A12 Chelmsford to A120 widening scheme

TR010060

Statement of Common Ground with Braintree District Council

Regulation Reference	Reg 8(1)(e)
Planning Inspectorate Scheme Reference	TR010060
Application Document Reference	TR010060/EXAM/8.14
Author	A12 Project Team and National Highways

**FIGURE 13.1**

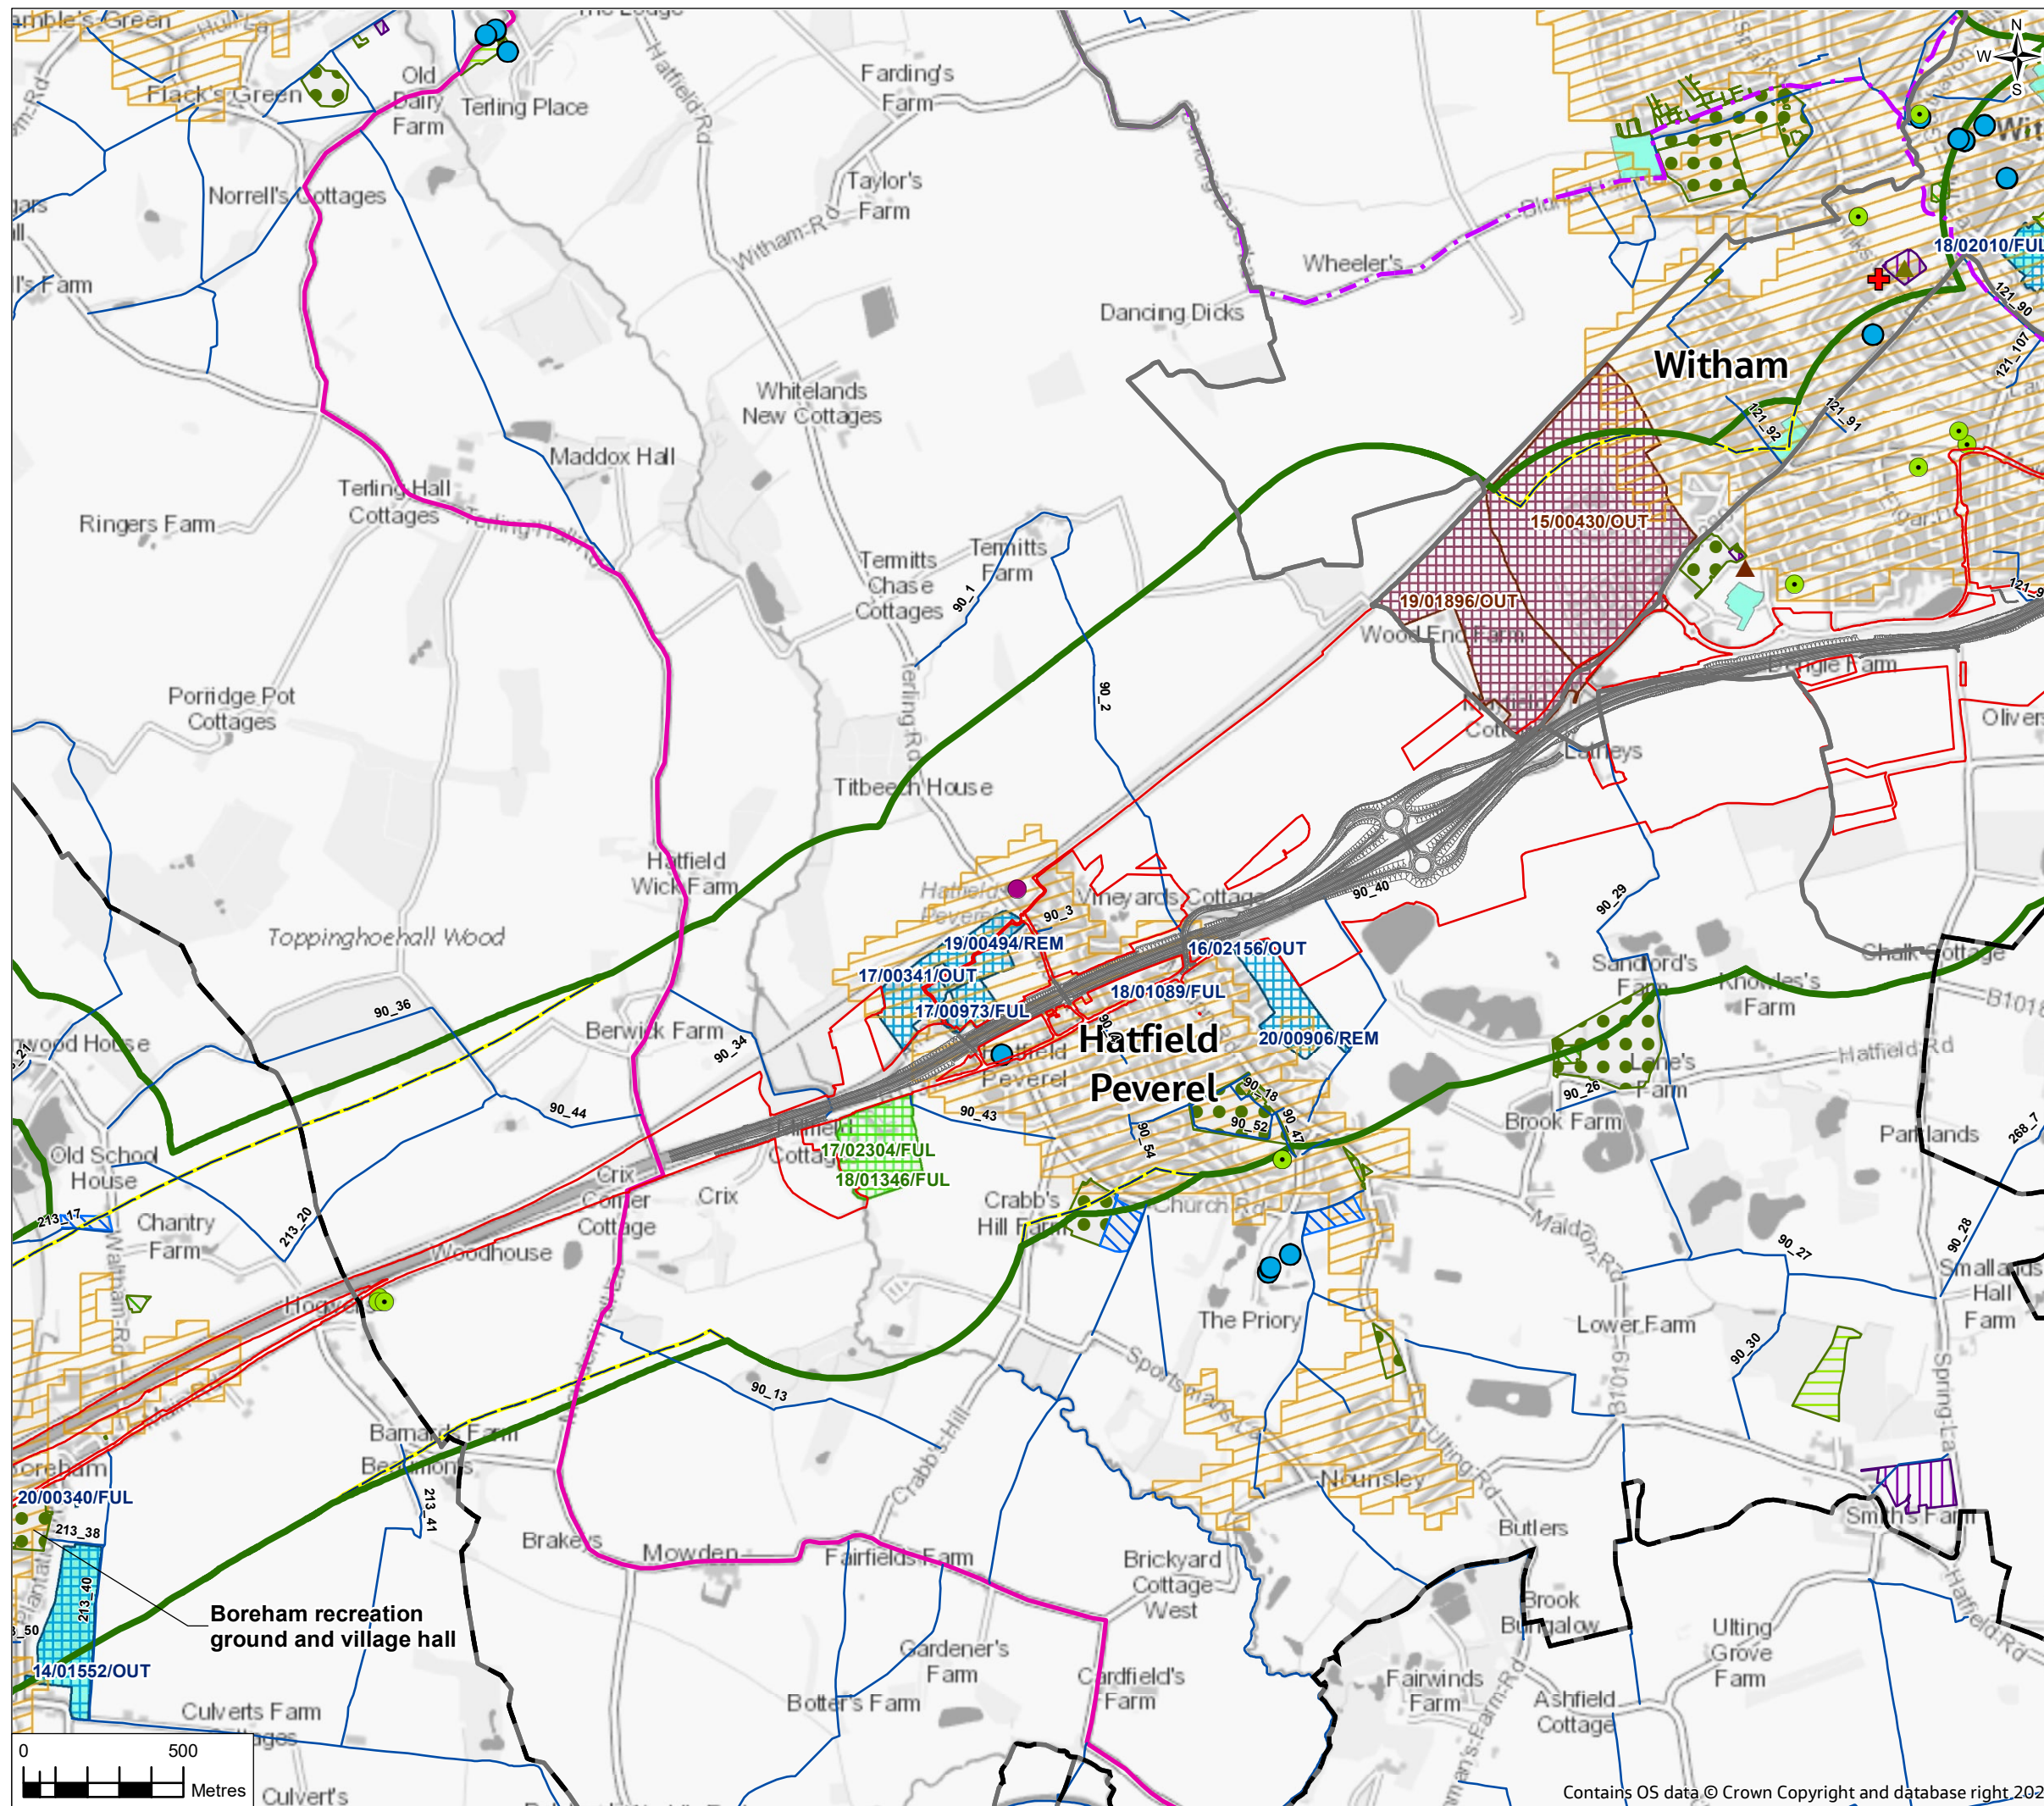
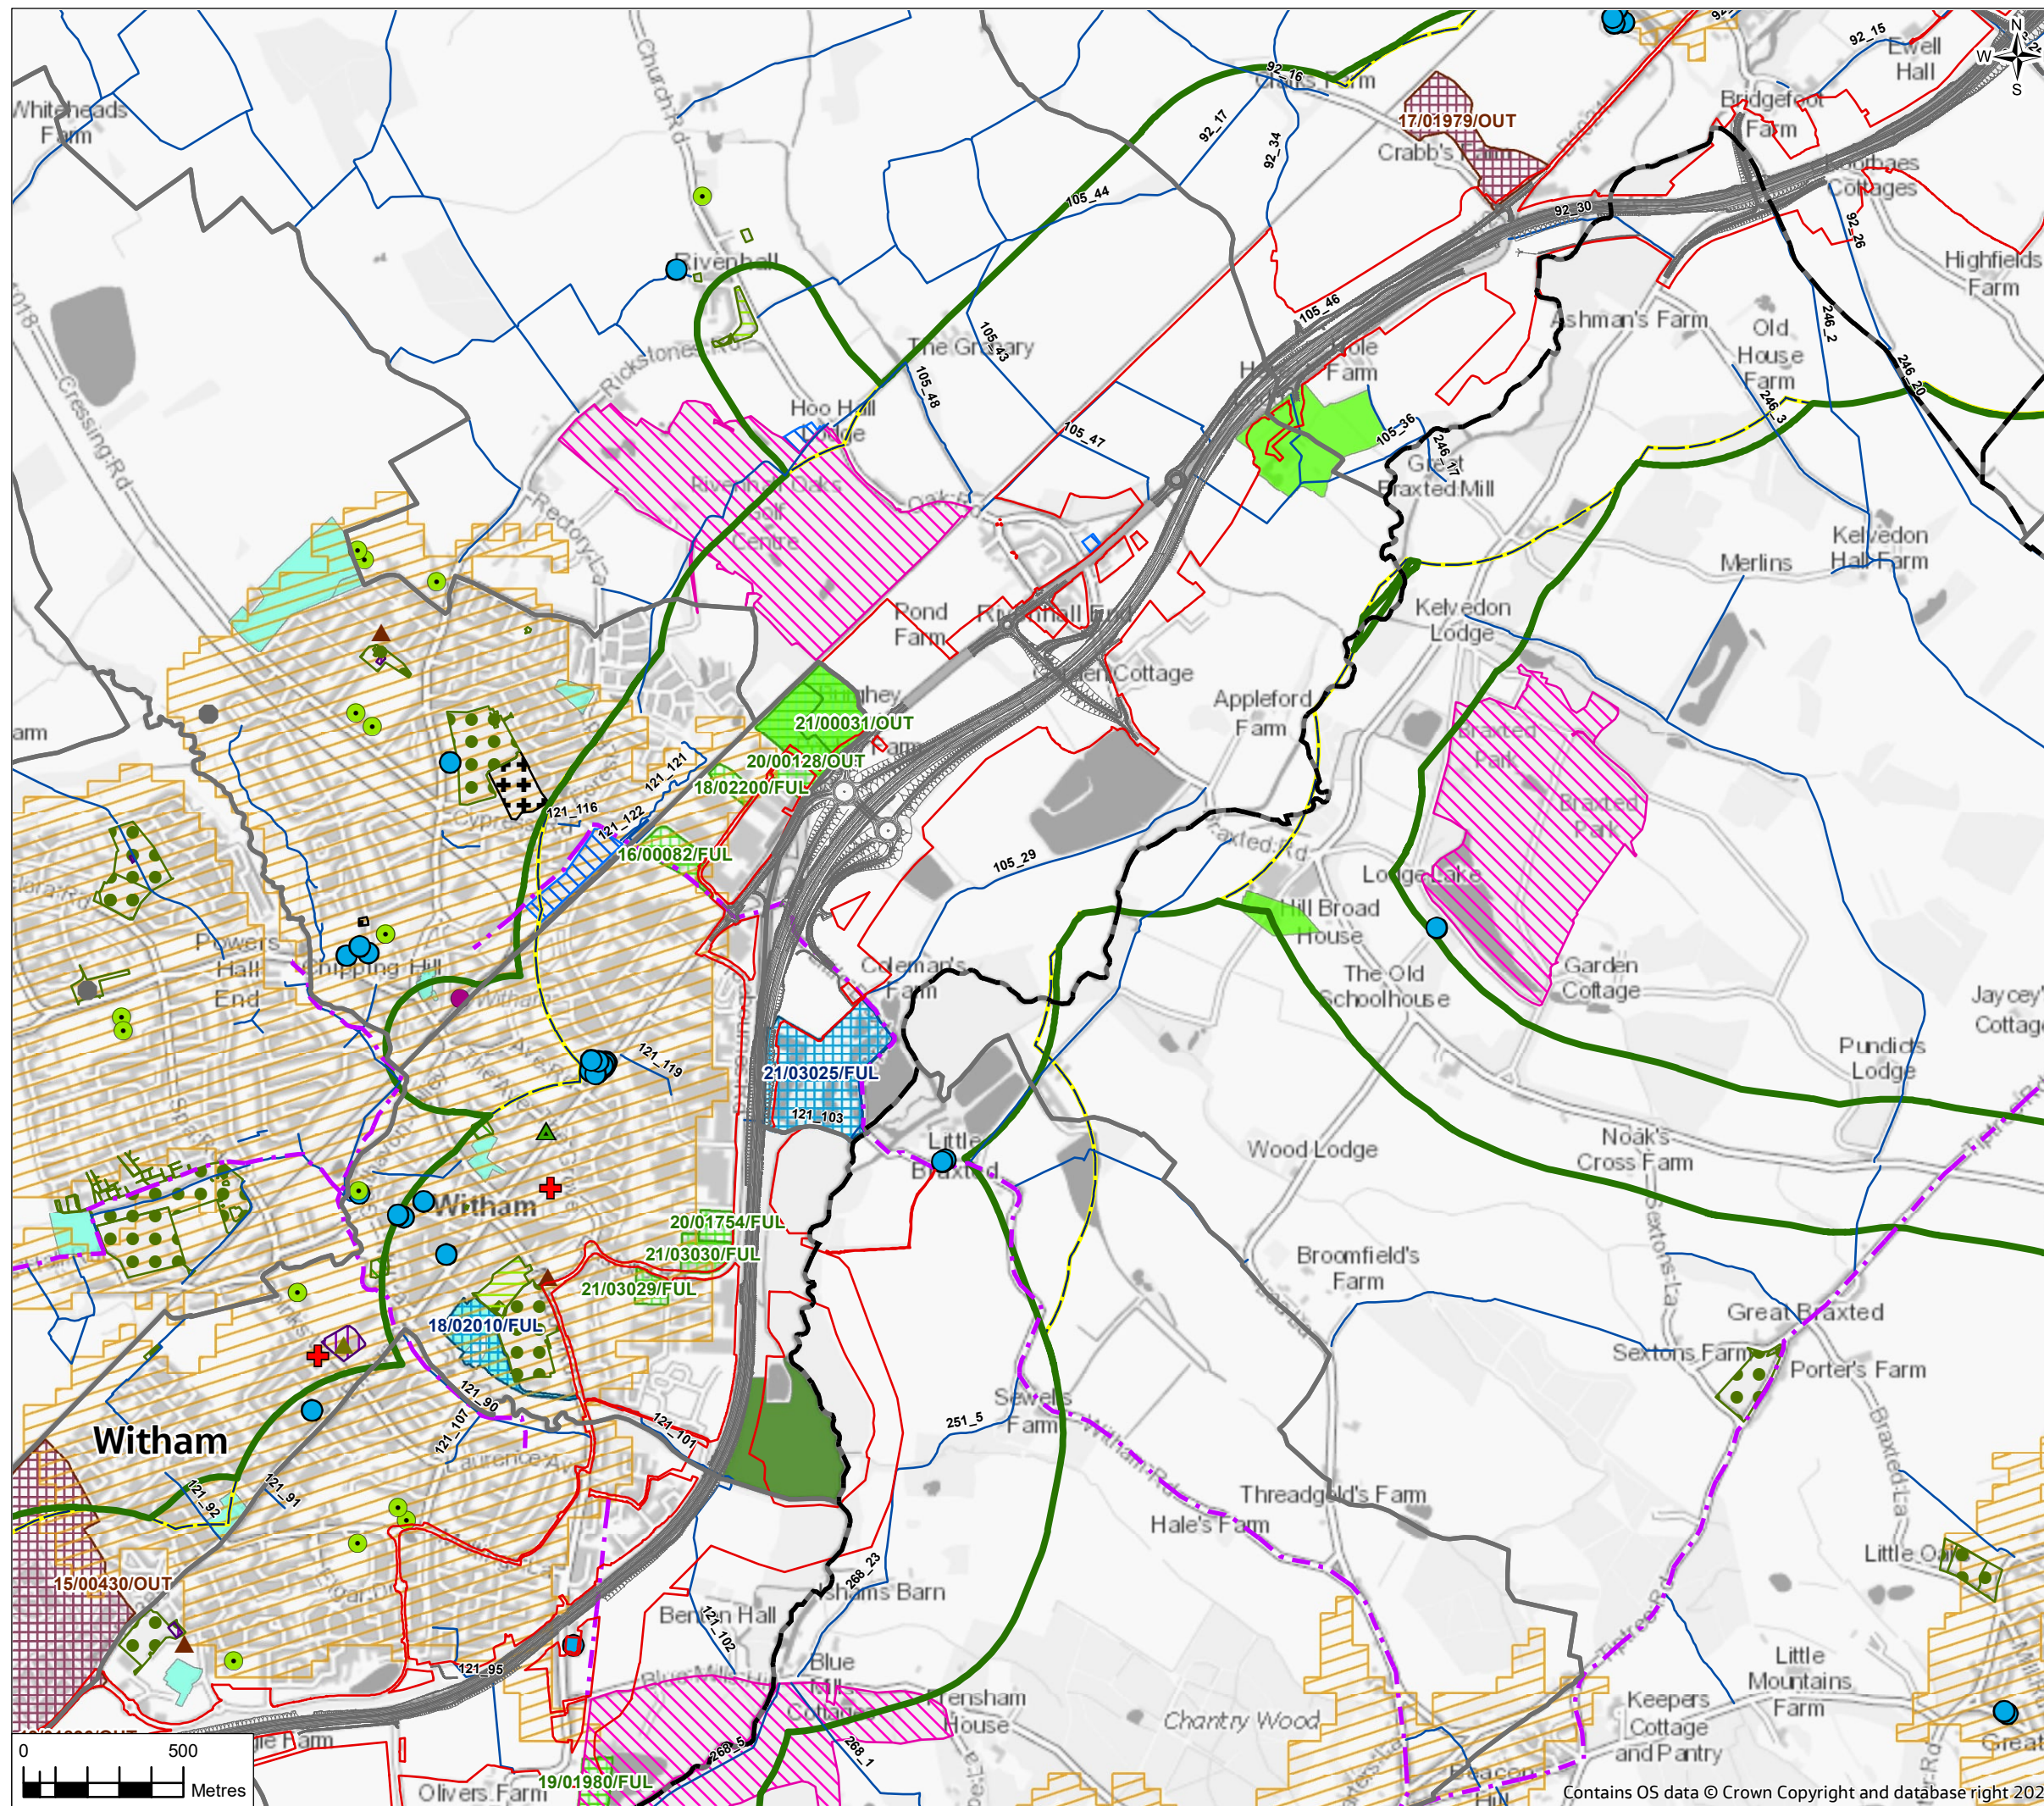
1.2	Environment – Human Health	Environmental Statement: Chapter 13: Population and human health [APP-080]	<p>The human health study area in the assessment as shown on figure 13.1 should include Nounsley, although the addition of this village is unlikely to affect overall outcomes.</p> <p>BDC agree that the Environmental Statement takes into account the village of Nounsley.</p>	<p>The village of Nounsley is outside of the study area for air quality and noise, as well as outside of the land use and accessibility study area as defined by DMRB LA 112. It is not considered there would be any likely significant effects for this village that warranted a need to extend the study areas.</p> <p>However, the village has been considered in the wider context of likely origins and destinations for people who may interact with the land use and accessibility study area.</p>	Agreed.	01/09/2022
